Land at Moor Lane, Gomersal

Reserved Matters Application 2025/92713 pursuant to outline permission 2023/92079 for erection of residential development of 10 dwellings

### **Summary of Changes to Layout, May 2026**

Client PPJ Developments  
 Project 2539 : Moor Lane : Residential  
 Title Proposed Site and Section

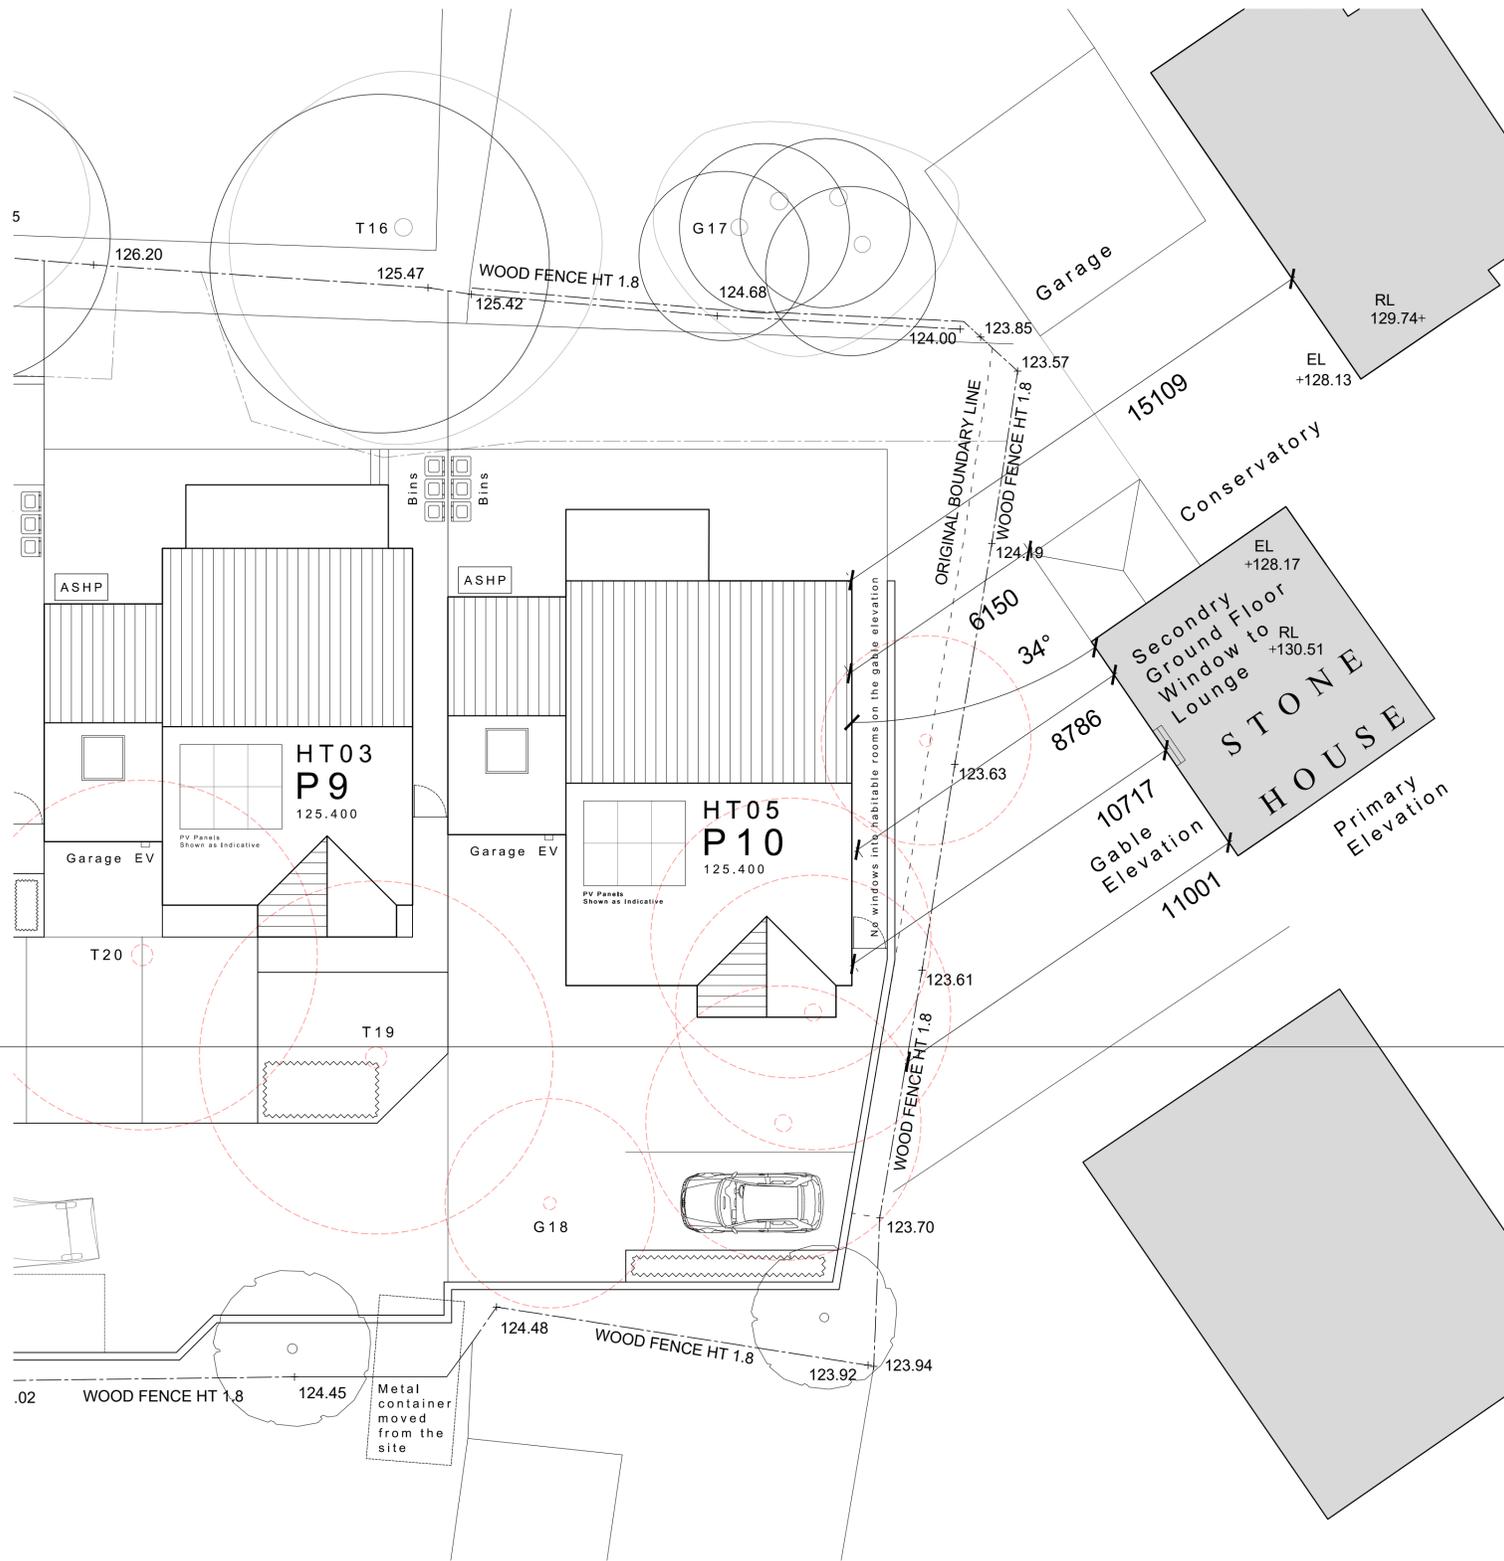
- 1) Visitor parking bays relocated
- 2) Bin collection point for Plots 6-10 relocated to be adjacent to the public highway
- 3) Minor changes to landscaping plan to be consistent with revised layout
- 4) Drainage strategy unchanged but drainage layout plan updated to be consistent with revised layout
